CHATBURN PARISH COUNCIL

25 March 2020

Planning Application No. 3/2020/0112 – Pendle Avenue

Datum 101.00m
Section AA' as 'Proposed'
Scale 1:50

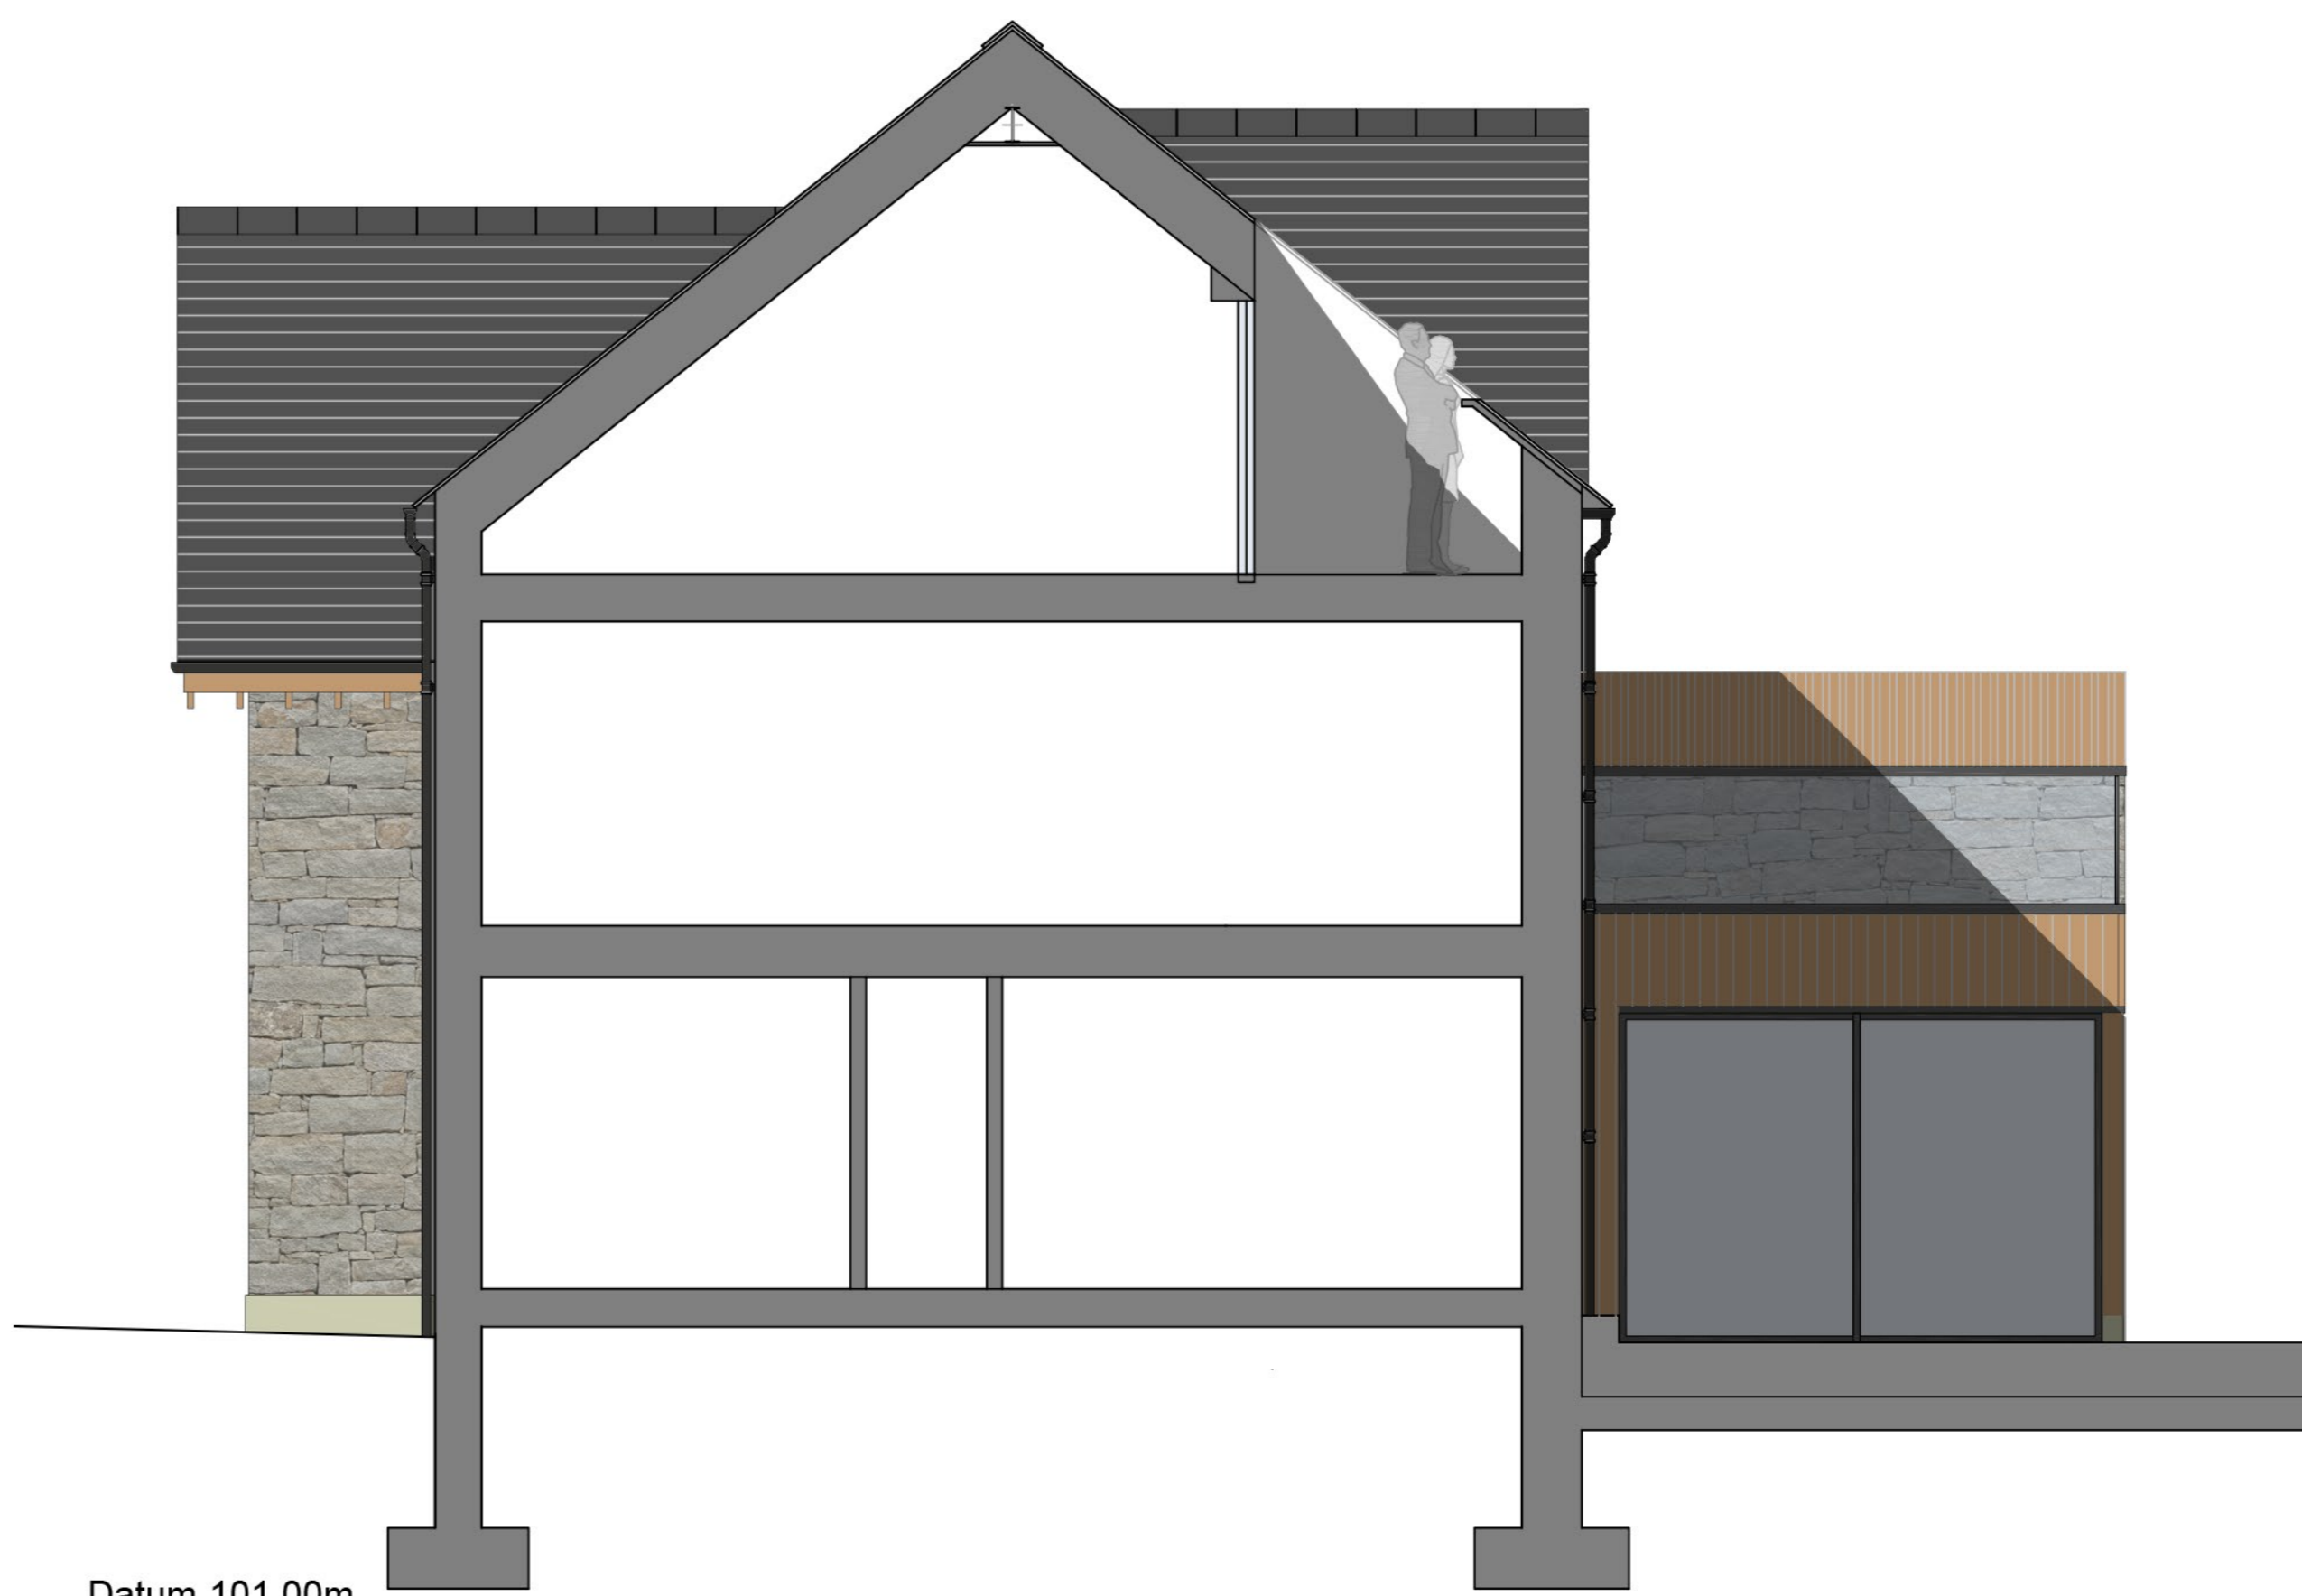
- Pendle Avenue is a private road and the proposed application is totally out of character with the existing properties
- Is there legal access to site?
- the height of the development will overshadow neighbouring properties causing loss of light.
